From: Amanda Scholes on behalf of Planning.Responses
Sent: 09 November 2020 08:43
To: Planning Scanning
Subject: FW: 3421 - 55-57 River Road - EA FRA response Ref HA/2020/122604/01-L01

From: Carl Gulland [REDACTED]
Sent: 06 November 2020 16:52
To: Anita Gardner <Anita.Gardner@arun.gov.uk>
Cc: Jane Wood [REDACTED]
Subject: Re: 3421 - 55-57 River Road - EA FRA response Ref HA/2020/122604/01-L01

Loss of privacy- Drawing 1908-P-305 Proposed North West Elevation illustrates an obscure glass balustrade adjacent to 5 Riverside Wharf ensuring an appropriate level of privacy whilst maintaining as open an aspect from 5 Riverside Wharf as possible

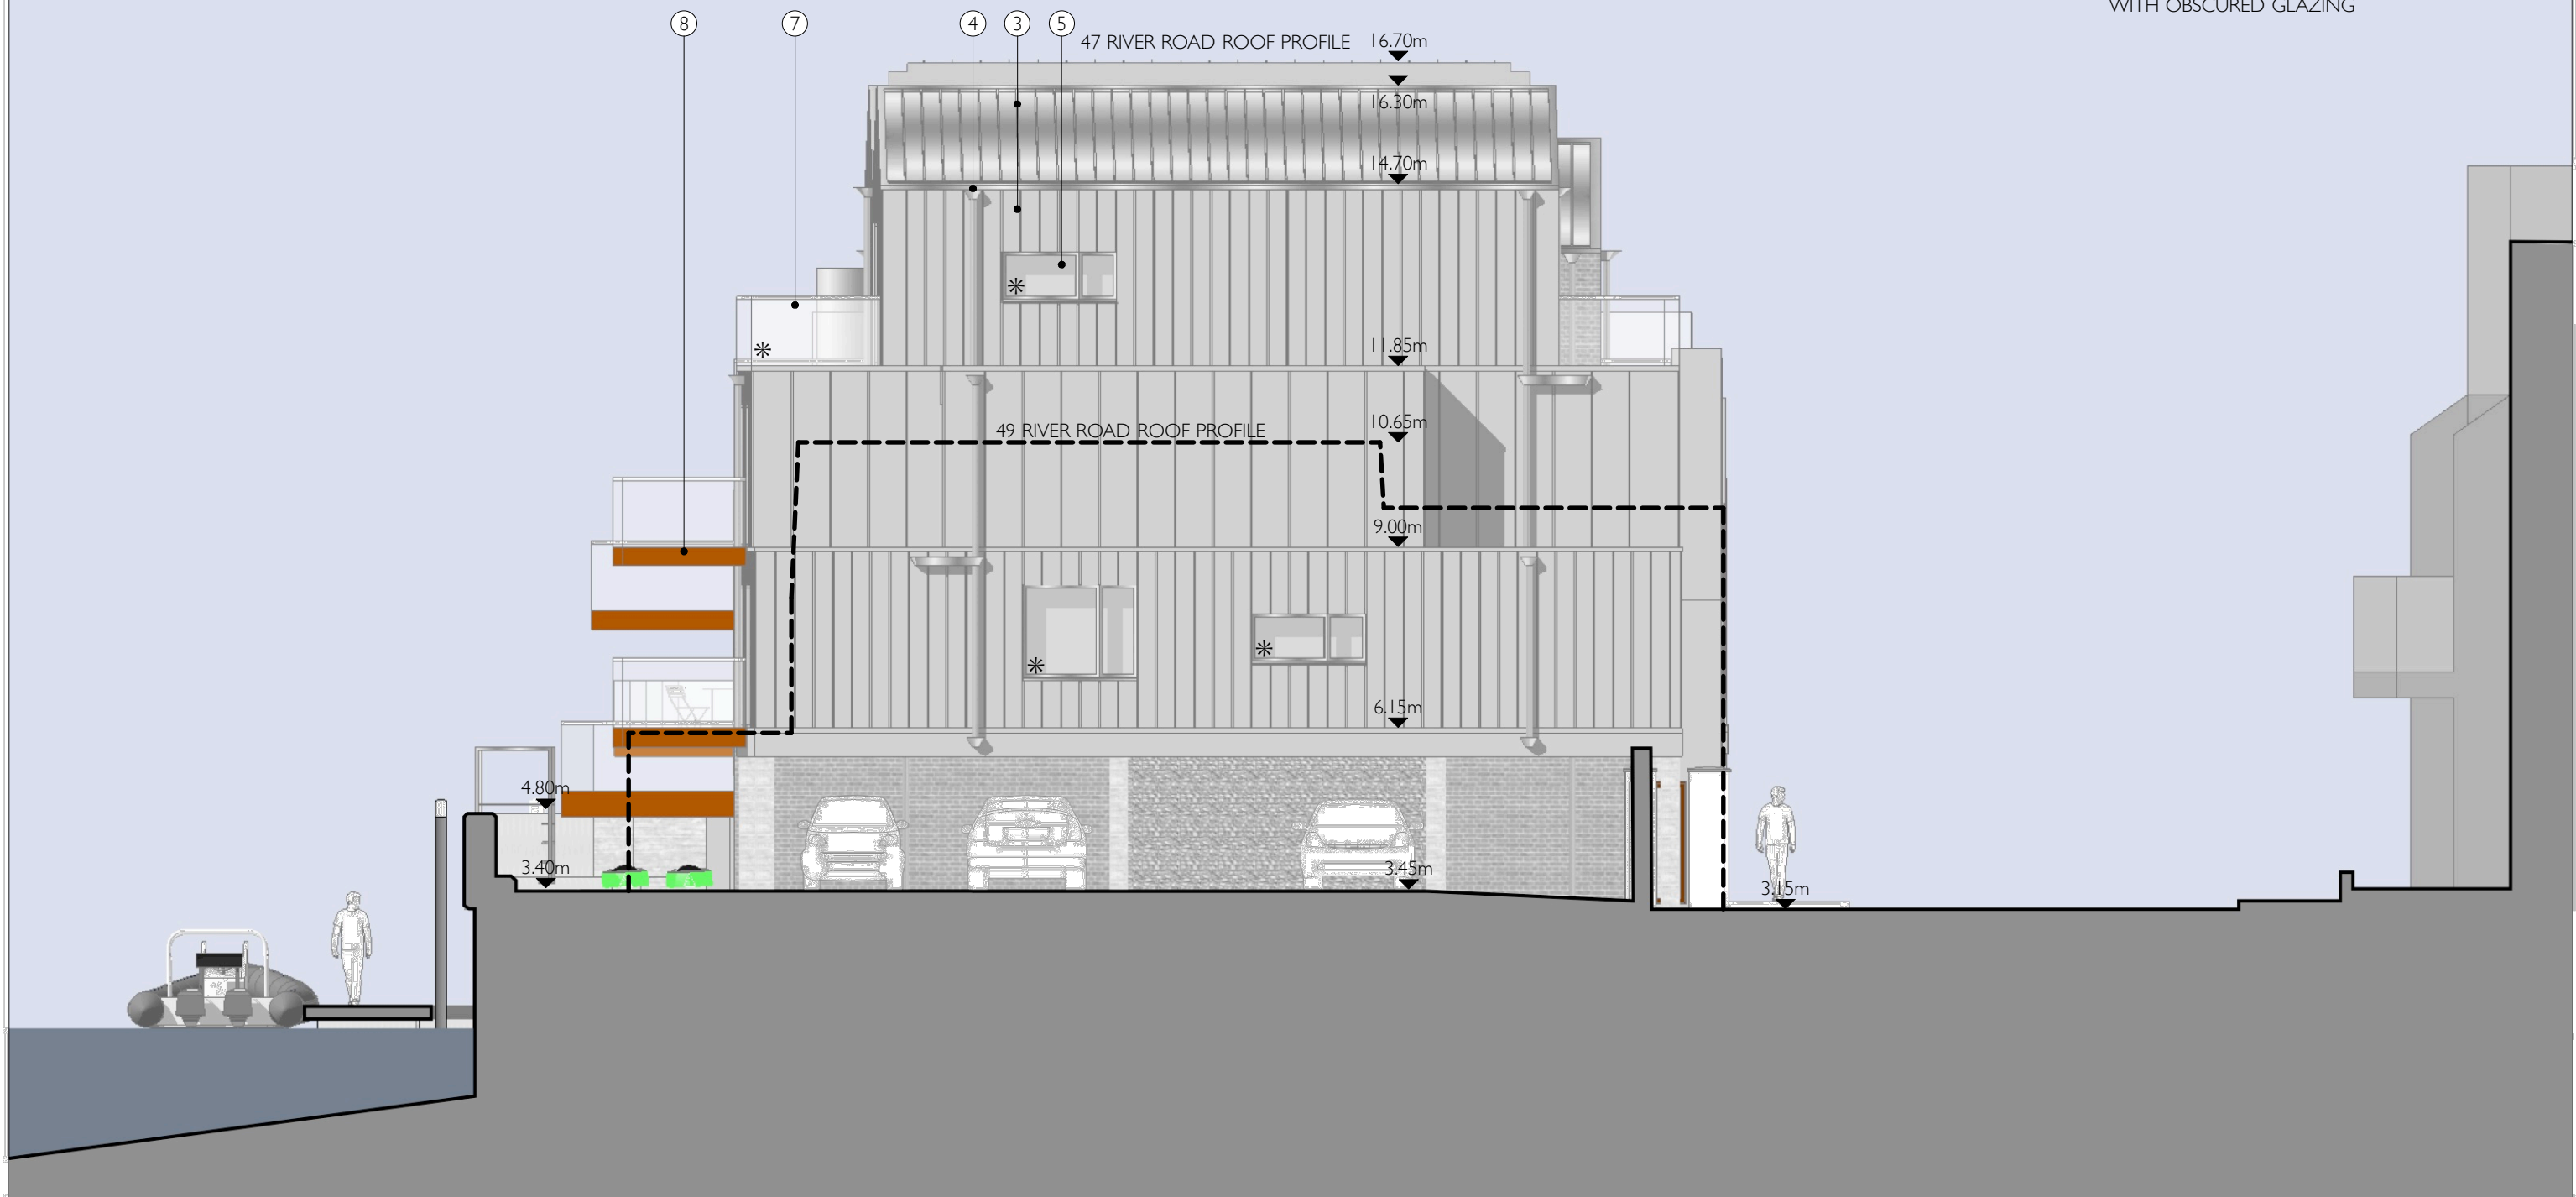
With regard to the second letter of from Mrs D Douglas, 5 Riverside Wharf, 47 River Road her objections are regarding loss of view, loss of sunlight, shading and loss of privacy:

REVISION 01 RED LINE CORRECTED TO TITLE BOUNDARY, PROPOSED S38 WORKS AMENDED + PONTOON SHORTENED
REVISION 02 MINIMUM FINISHED FLOOR LEVEL RAISED TO ABOVE 5.17M AOD TO REFLECT UPDATED FLOOD RISK DATA

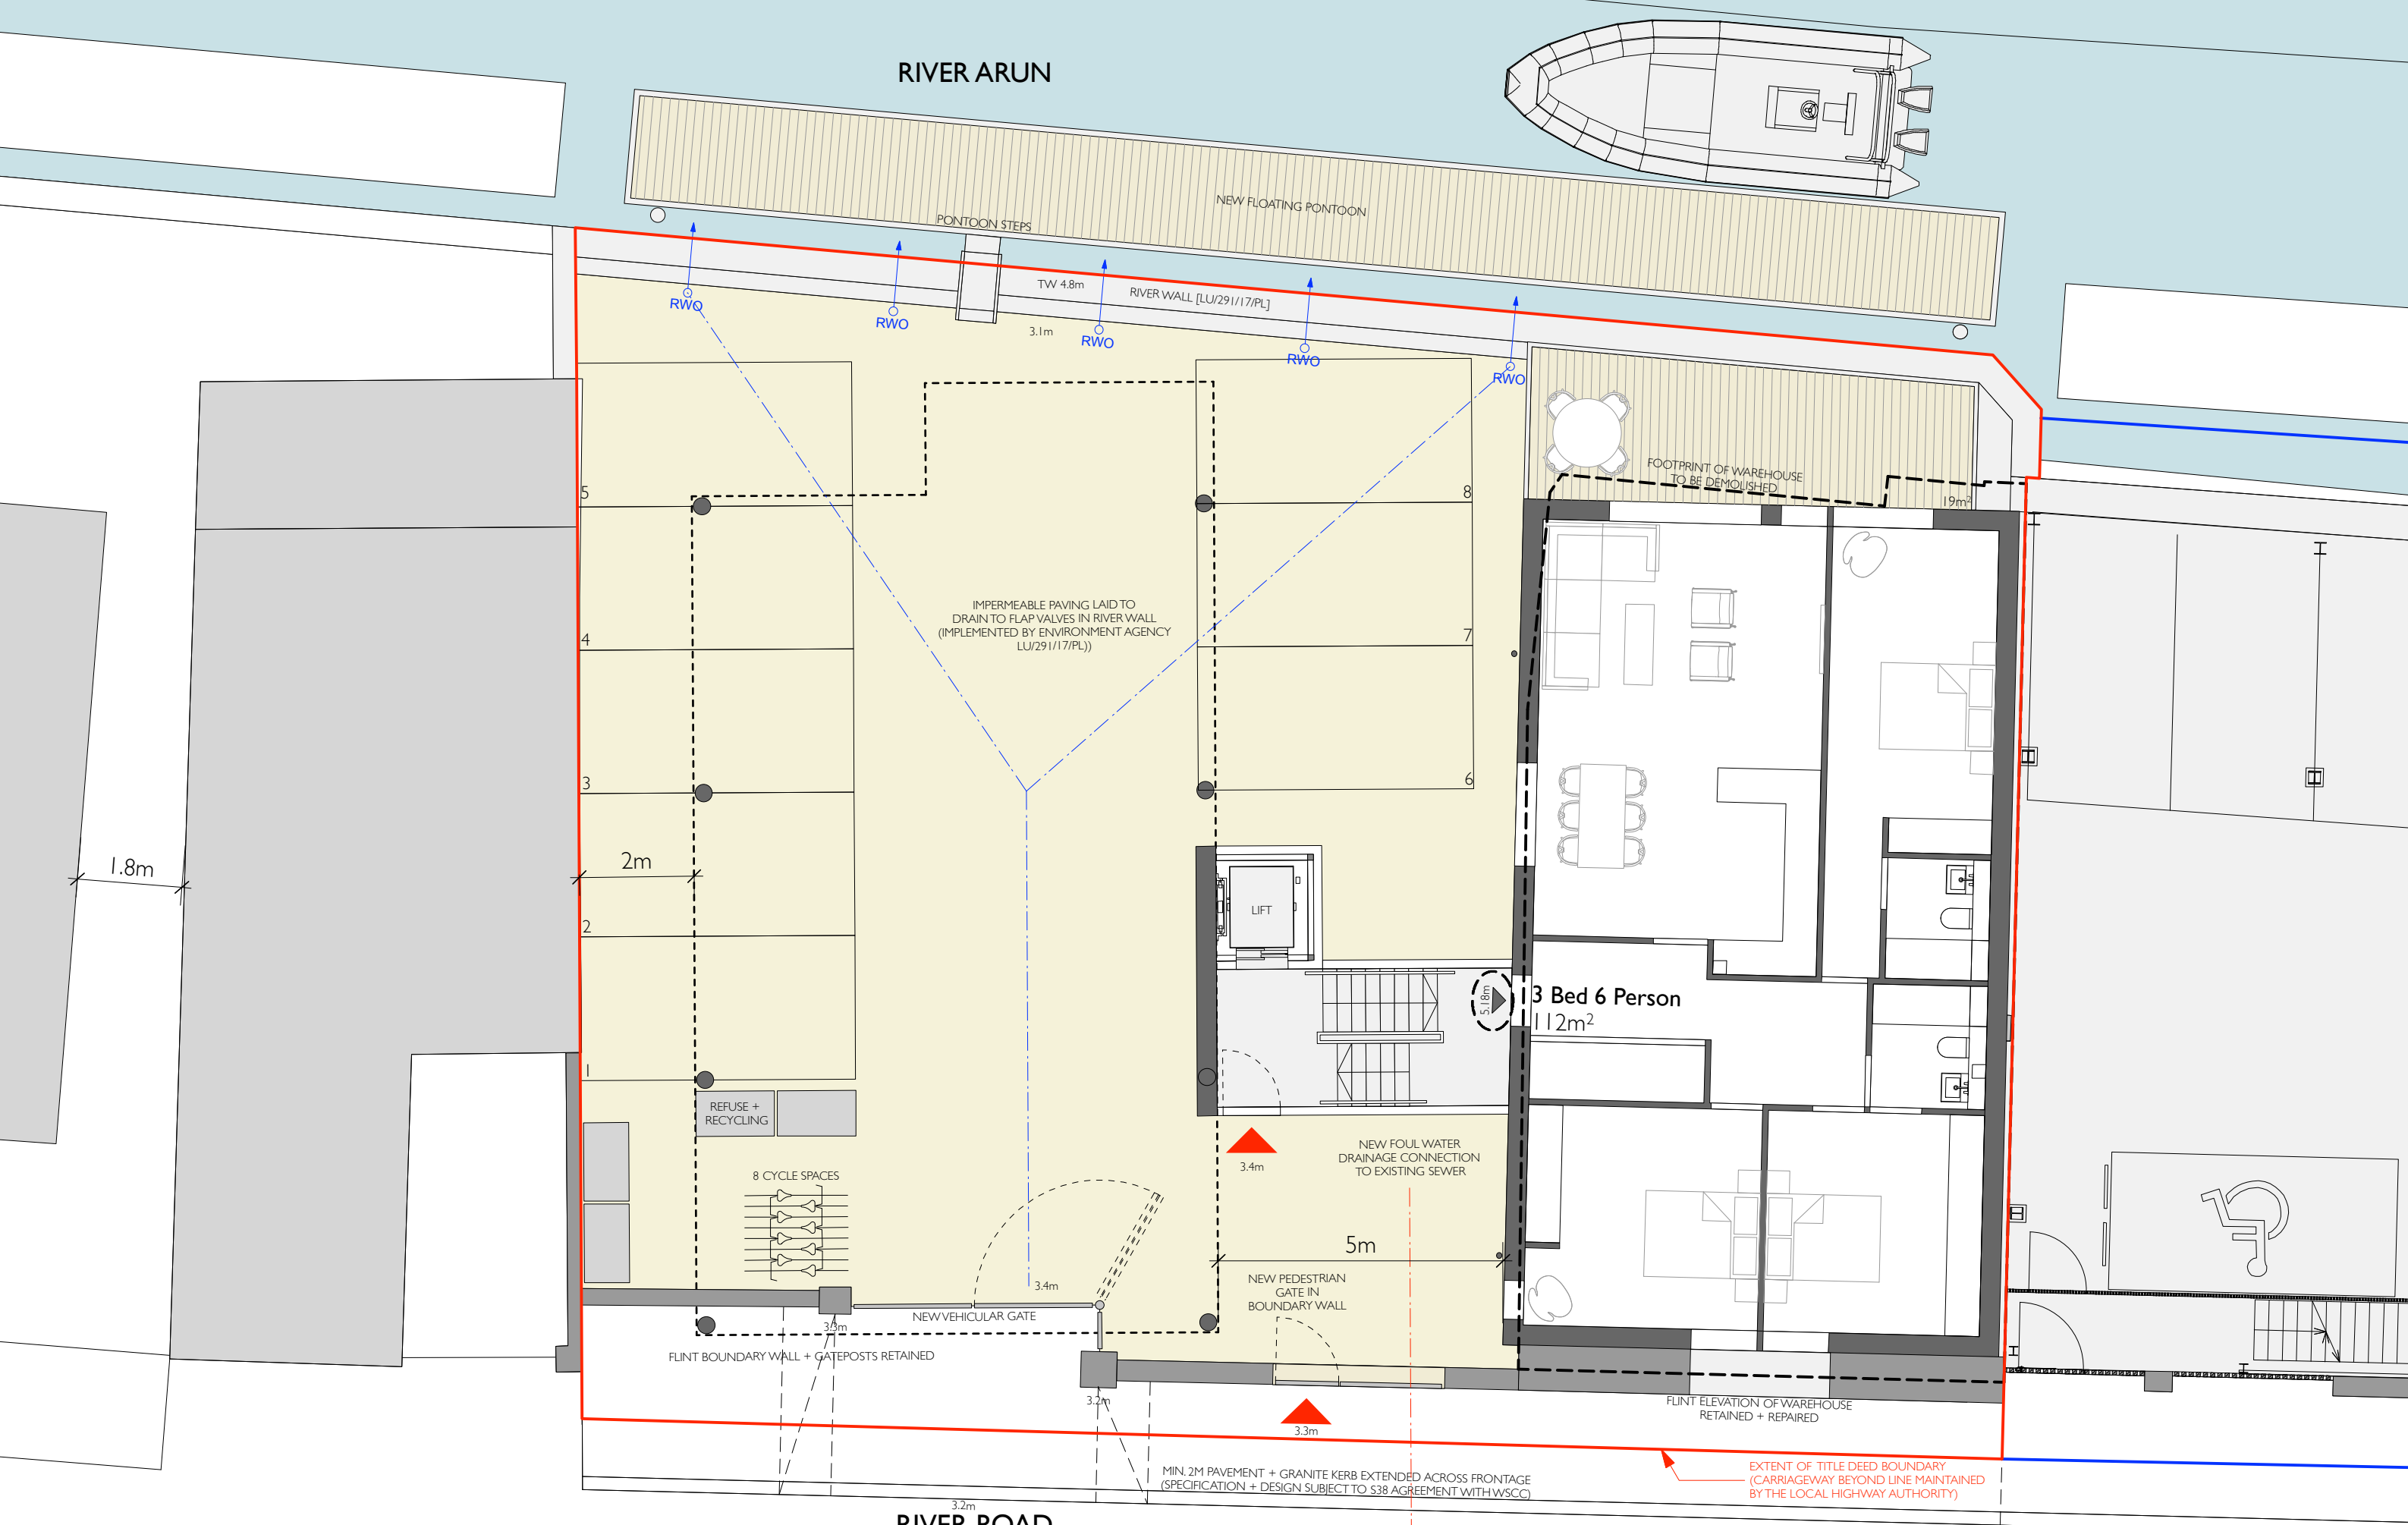
Please treat the document as a substitute FRA. The updated flood data requires the finished floor levels (FFL) of the wing adjacent to 47 River Road to be raised by 4cm. I can amend the plans and elevations to reflect this with a note confirming what will be a fairly indiscernible change? The overall height of the wing won't change as the roof pitch can be fractionally reduced. Alternatively I wondered if a condition noting that the FFLs must be no lower than 5.17m AOD would be an acceptable way of dealing with the issue?

To highlight, the product 4 confirms the flood levels would reach up to 4.87m AOD for a 1:200 yr AEP event in 2115. Allowing a 300mm freeboard, the habitable place would be protected to the required level of 5.17m AOD. JPA will update the levels to suit.
